From: Nicola Oktay on behalf of Planning.Responses
Sent: 09 April 2025 12:29
To: Planning Scanning
Subject: FW: RE: Planning consultation on: BR/50/25/PL

Planning Consultee response – Arun Houses in Multiple Occupation Officer

Please see Private Sector Housing comments below. These comments are in relation to general housing conditions and have regard to the Housing Act 2004, Housing Health and Safety Rating System (England) Regulations 2005 and LACoRS national fire safety guidance.

Main building - First Floor

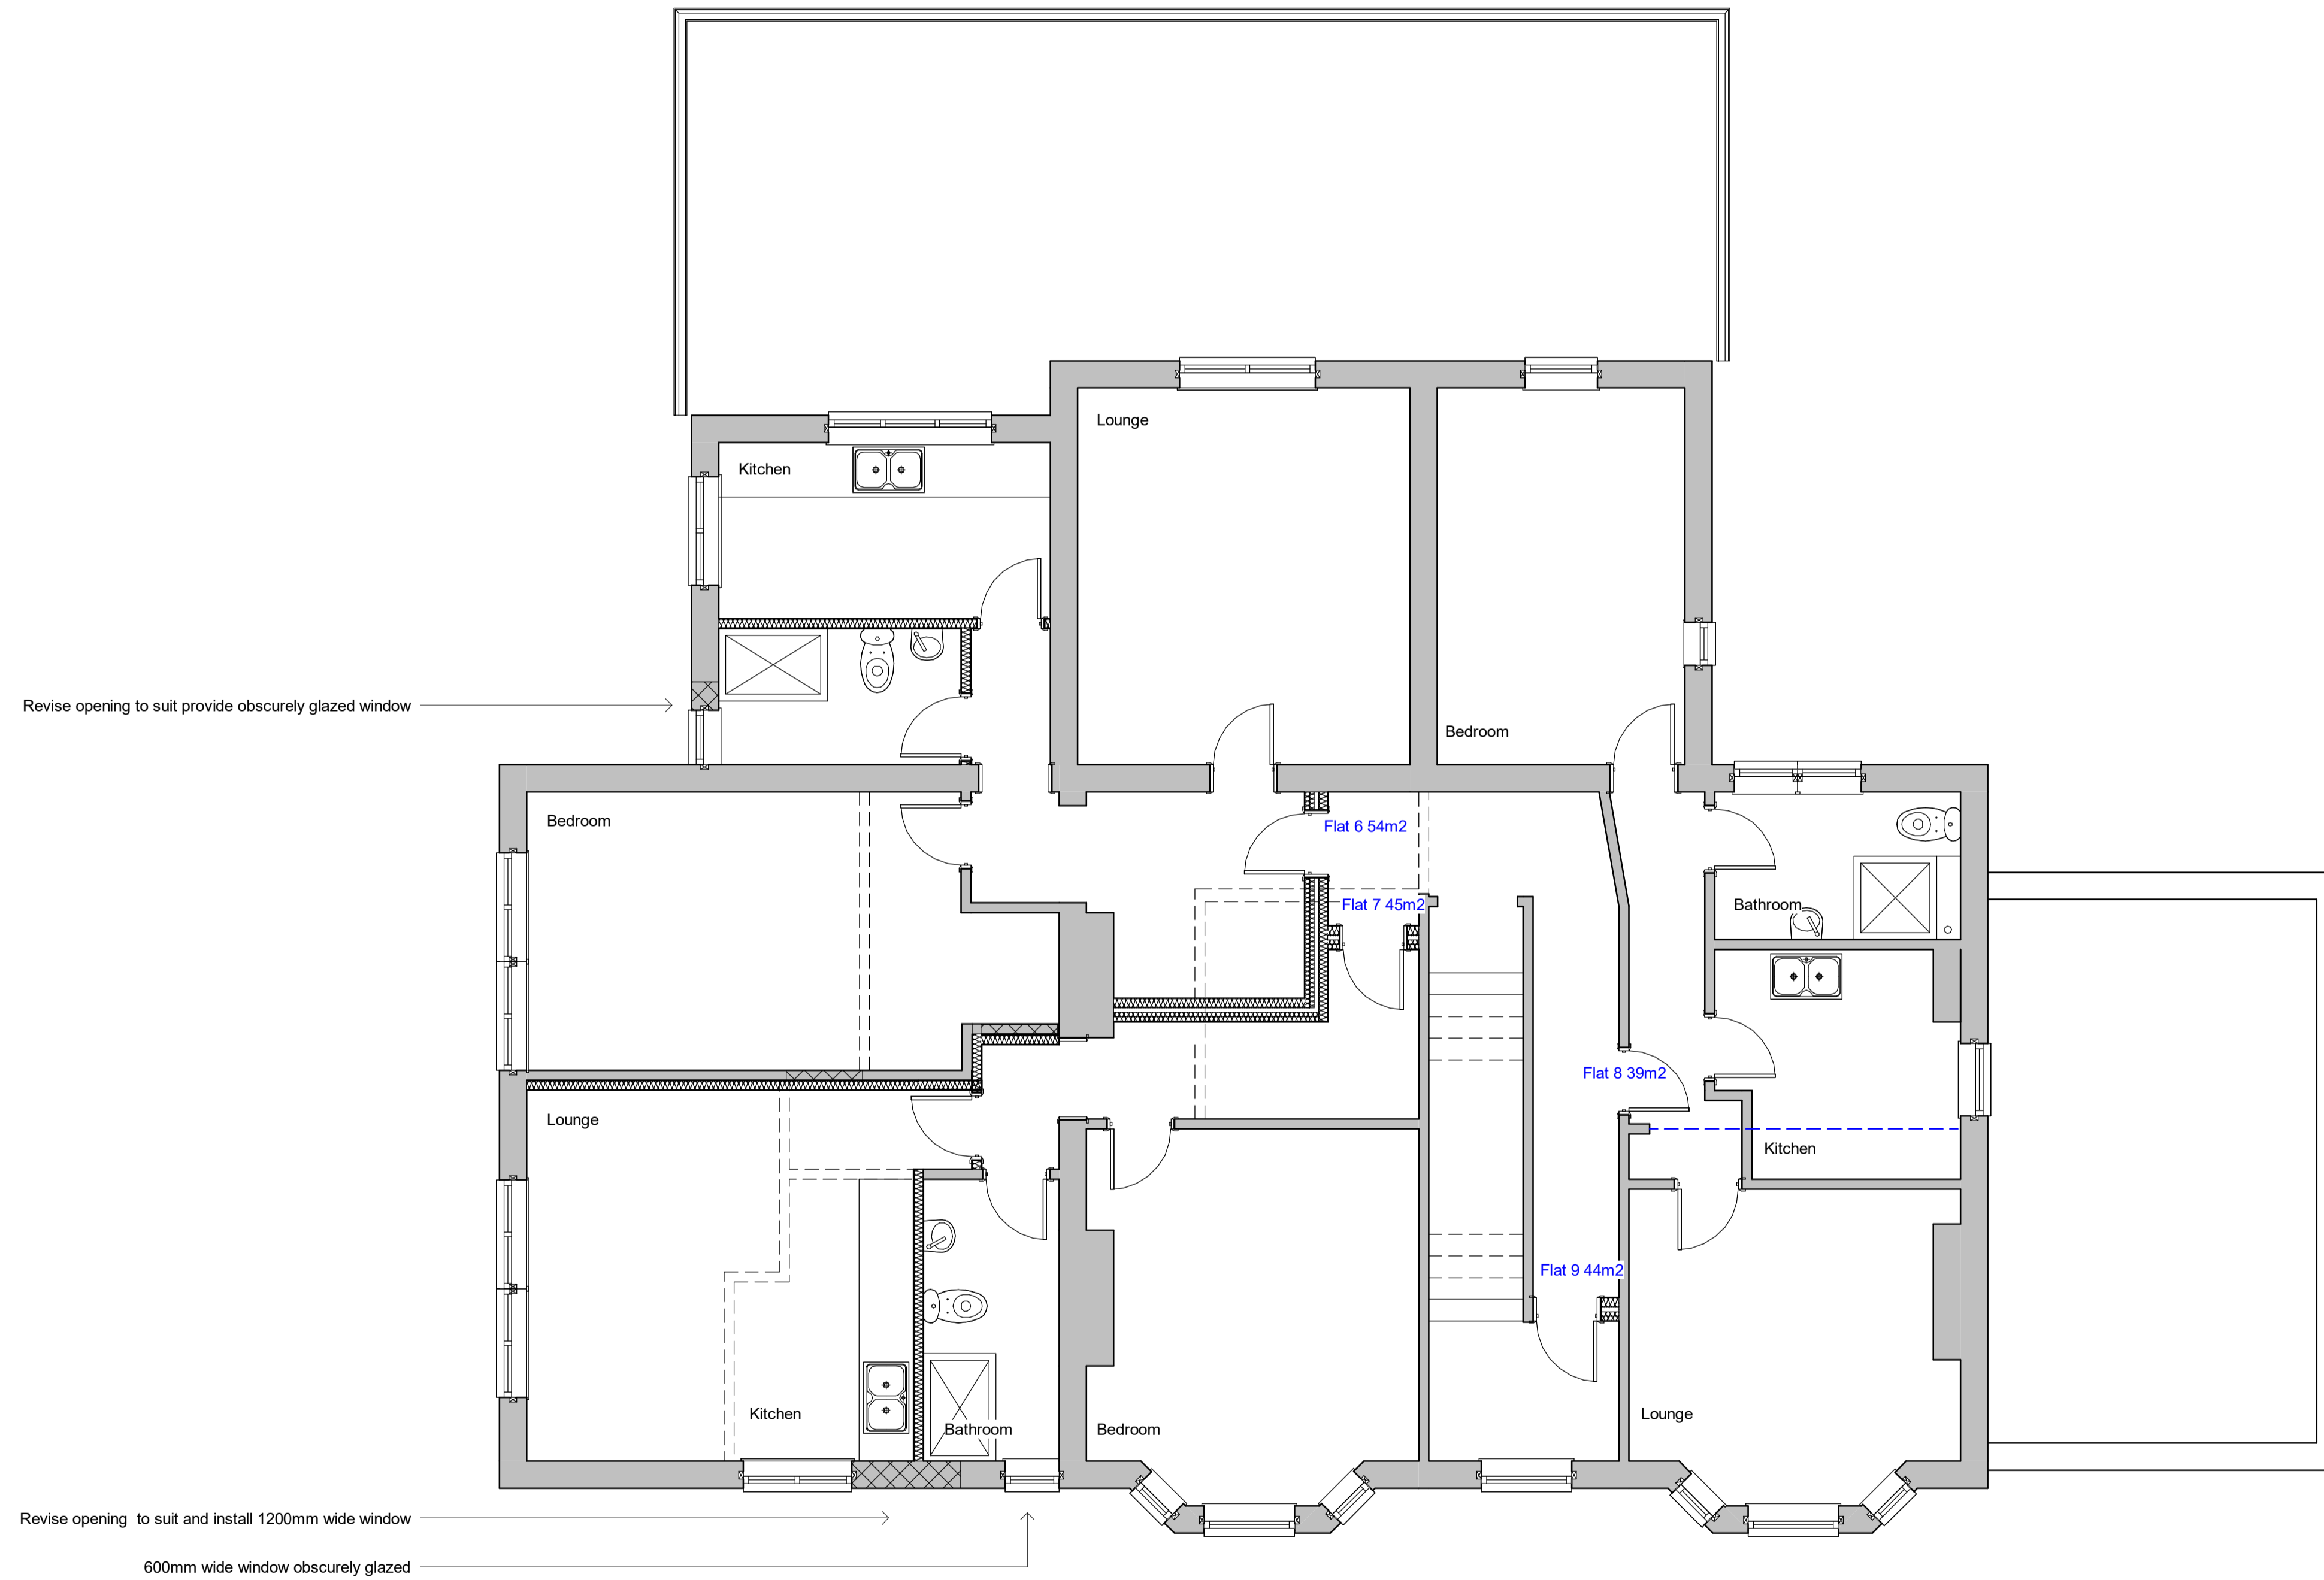
- The bedrooms within Flats 1, 3, 4 & 10 are inner rooms. A room where the only escape route is through another room is termed an “inner room” and poses a risk to its occupiers if a fire starts unnoticed in the outer room. In both cases, the outer rooms are the lounge/kitchen which are high risk rooms. This can be overcome by providing the following additional fire safety measures:
- Escape windows installed to the bedrooms to provide an alternative means of escape;
- FD30S doors fitted to the bedrooms; and
- Smoke detection installed to the kitchen/living room (liaise with a fire alarm engineer for best placement to avoid false alarms from cooking) with an interlinked smoke detector installed to the inner hallway

However, consideration should be given to reconfiguring the layout of the individual flats to prevent inner rooms.

- The internal communal escape route should provide a minimum of 30 minutes fire resistance, including any service cupboards and understairs areas, and 30-minute fire resisting and self-closing fire doors (FD30S) must be fitted to each flat entrance door. Doors to any service cupboards and understairs areas must also be 30 minute fire-resisting and kept shut with a lock and with appropriate signage.
- All final exit doors from the building, and from each individual unit into the internal escape route should be fitted with an internal thumb turn latch

- A mixed Grade A, LD2 and Grade D LD3 fire alarm system should be installed and maintained. Grade A detection comprises electrically operated smoke and heat detectors which are linked to a control panel. The control panel must conform to current BS 5839: Part 4 or equivalent and incorporate manual call points next to final exits and on each landing. Grade A: LD2 coverage is required in the common areas and a heat detector in each flat in the room/lobby opening onto the escape route (interlinked). Grade D: LD3 coverage in each flat (non-interlinked smoke alarm in the room/lobby opening onto the escape route) to protect the sleeping occupants

Main building - Second Floor

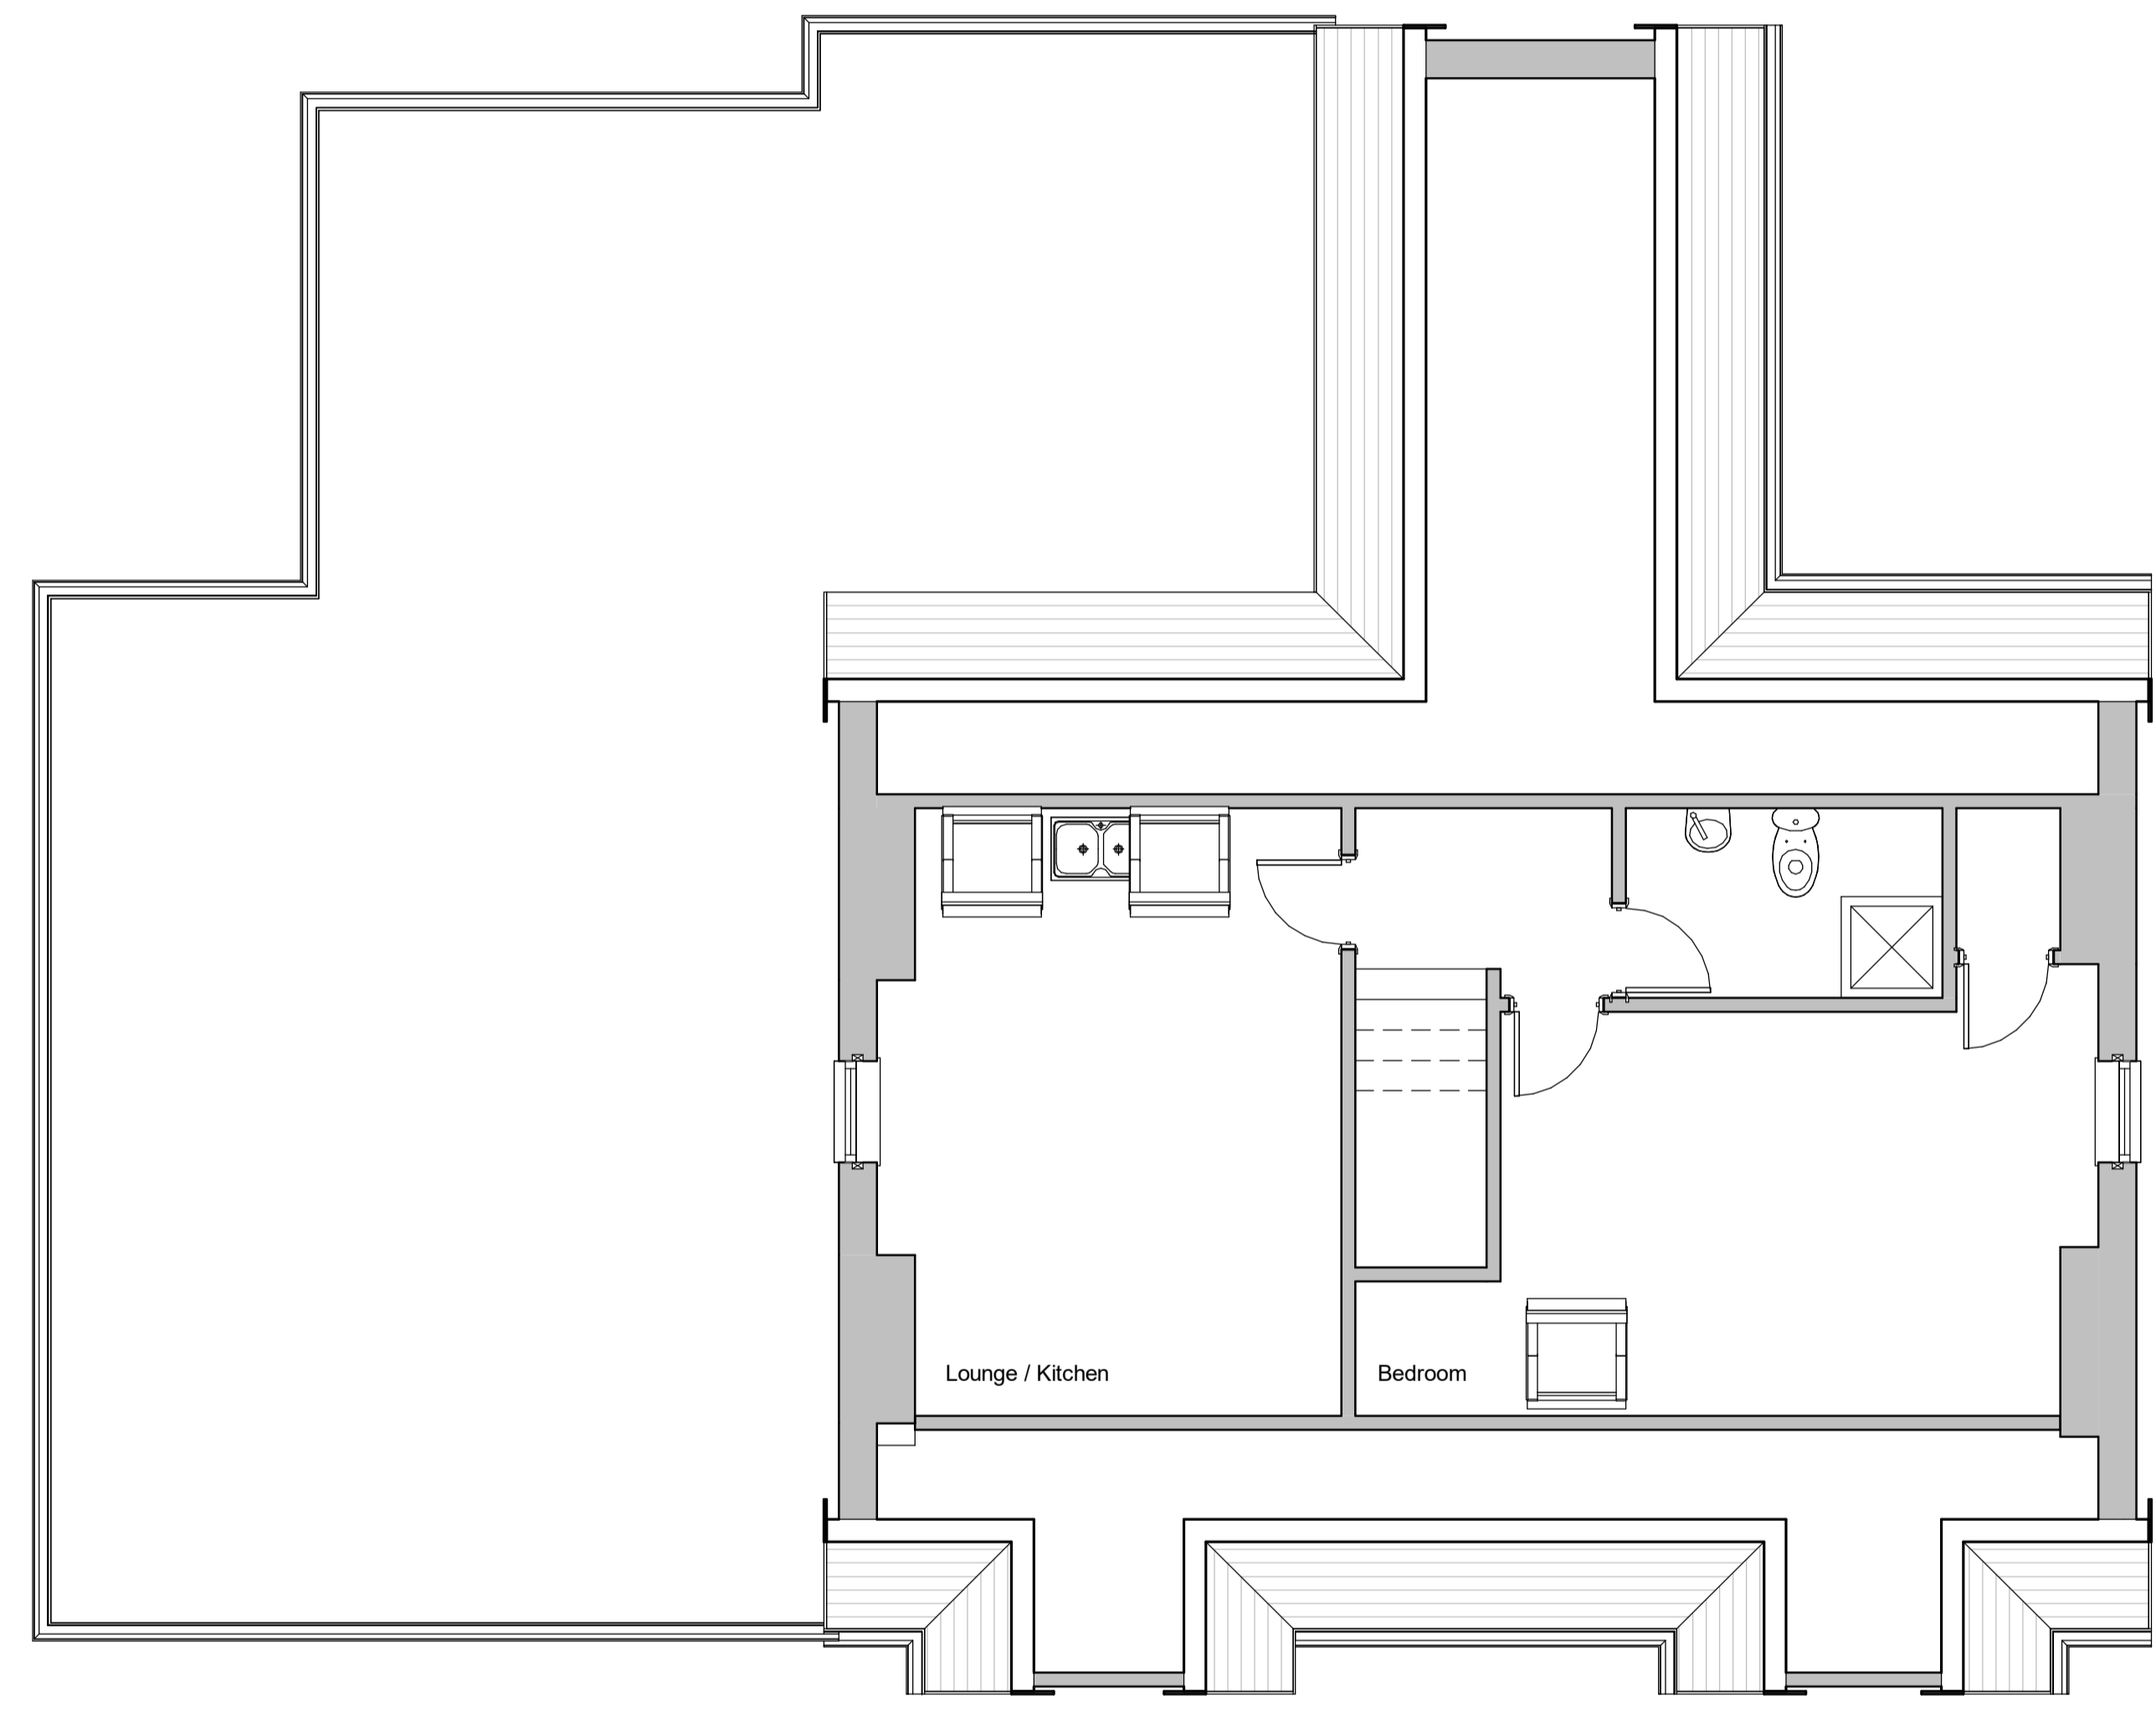
- Opening limiters should be installed to all windows above the ground floor to prevent windows being opened more than 100mm. Opening limiters should not be key operated
- The roof windows serving Flat 9 should be of an appropriate height and angle to provide a reasonable view outside of the immediate surroundings

Detached Unit (former communal area) - Ground Floor

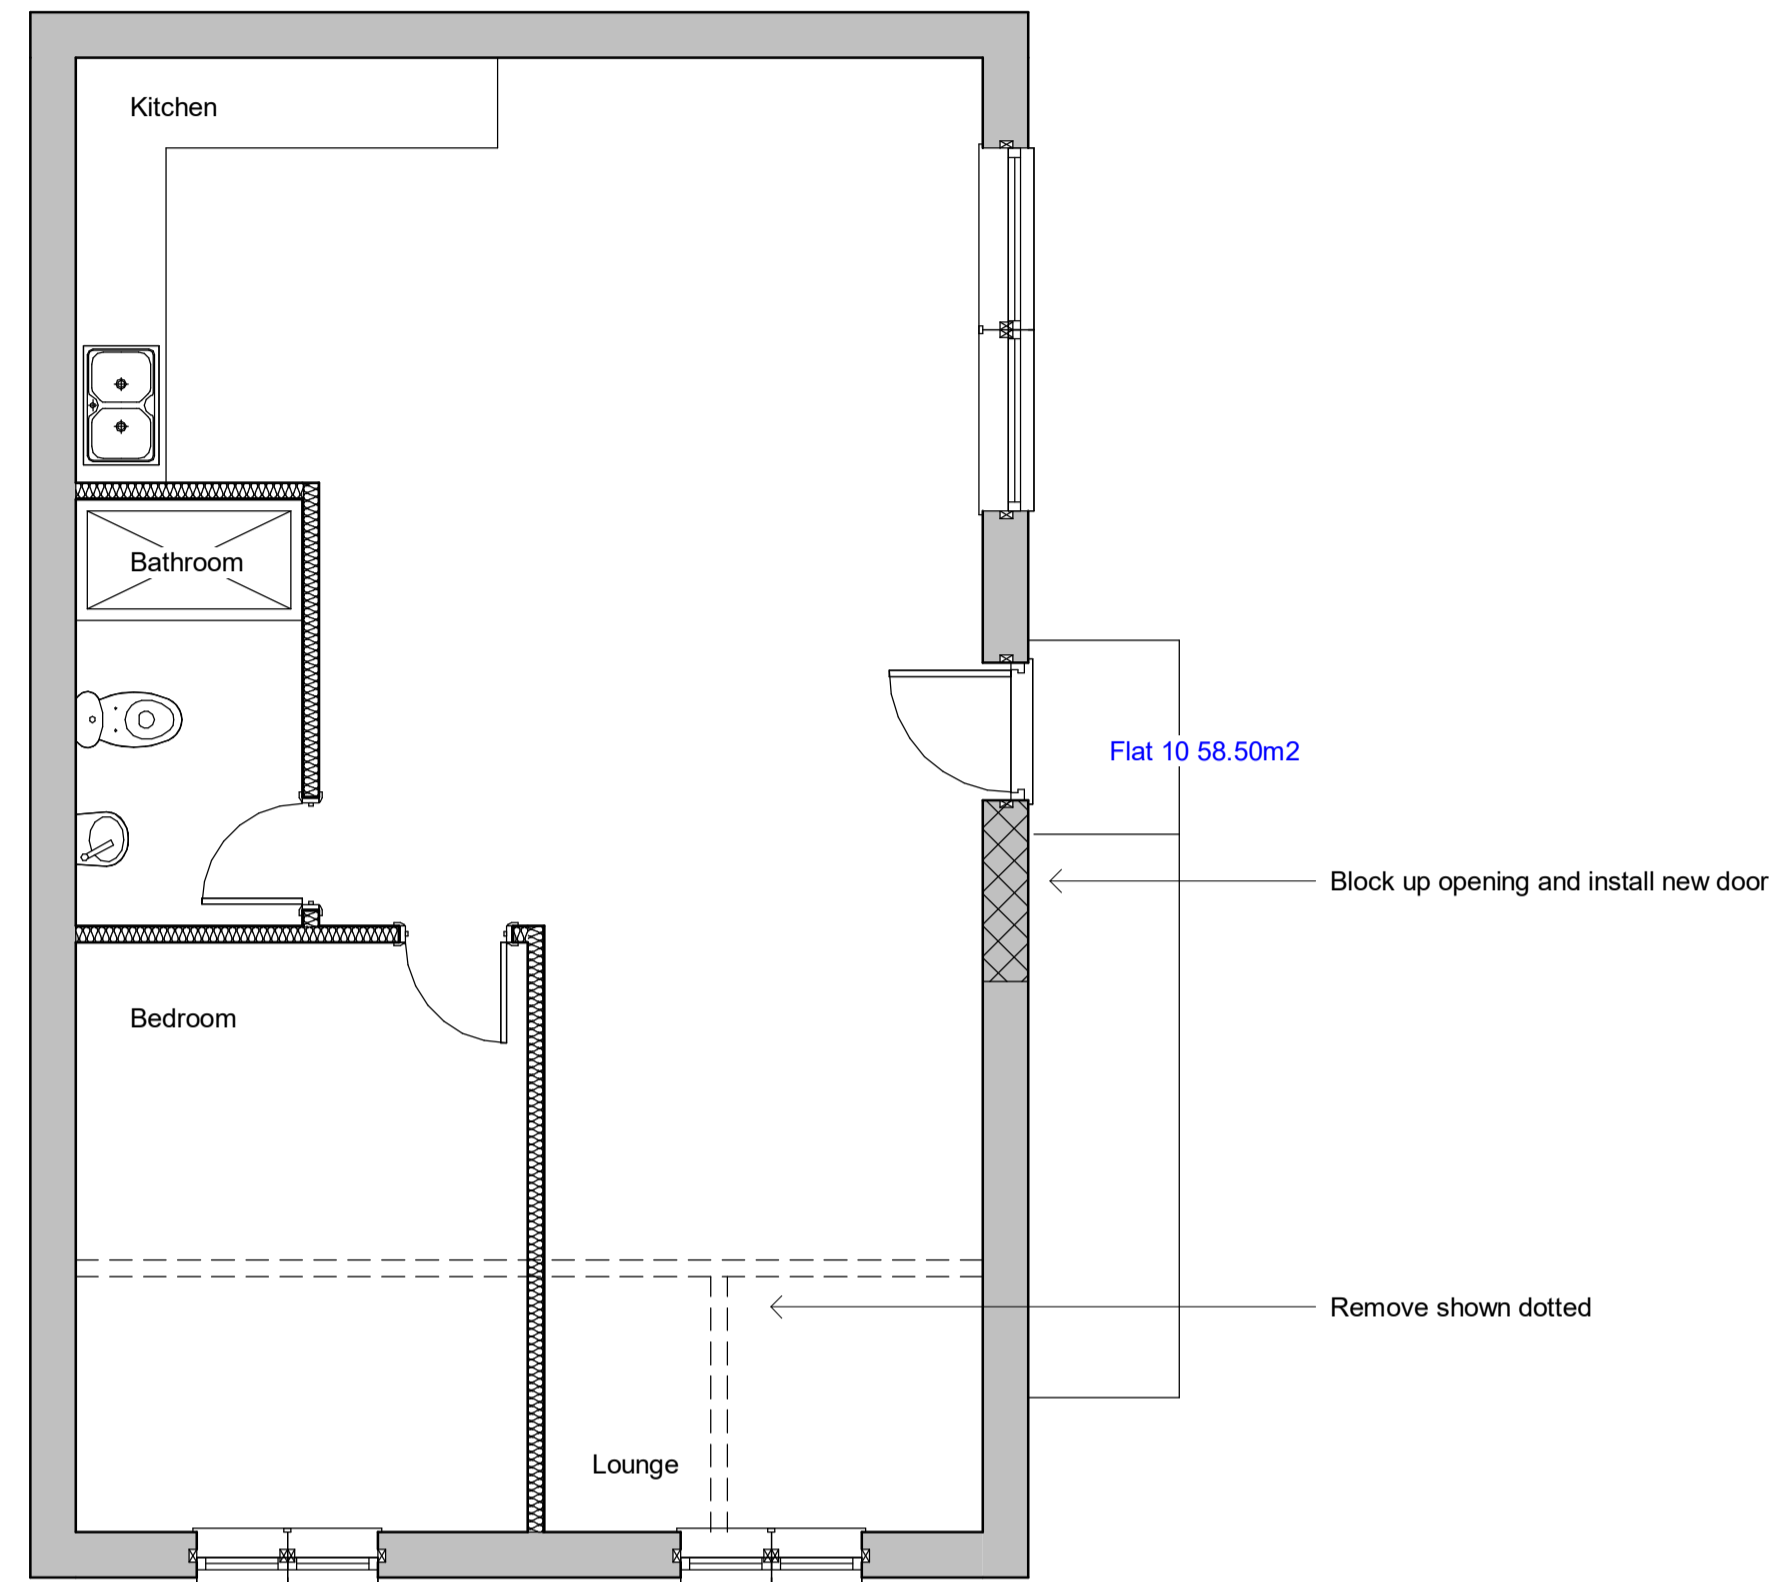
- Conventional and emergency lighting to be provided throughout the internal escape route
- Flat 10 (detached unit) may require interlinked detection with the Grade A system in the main building, as well as its own dedicated Grade D system, however further comment should be sought from the Fire Risk Assessor.
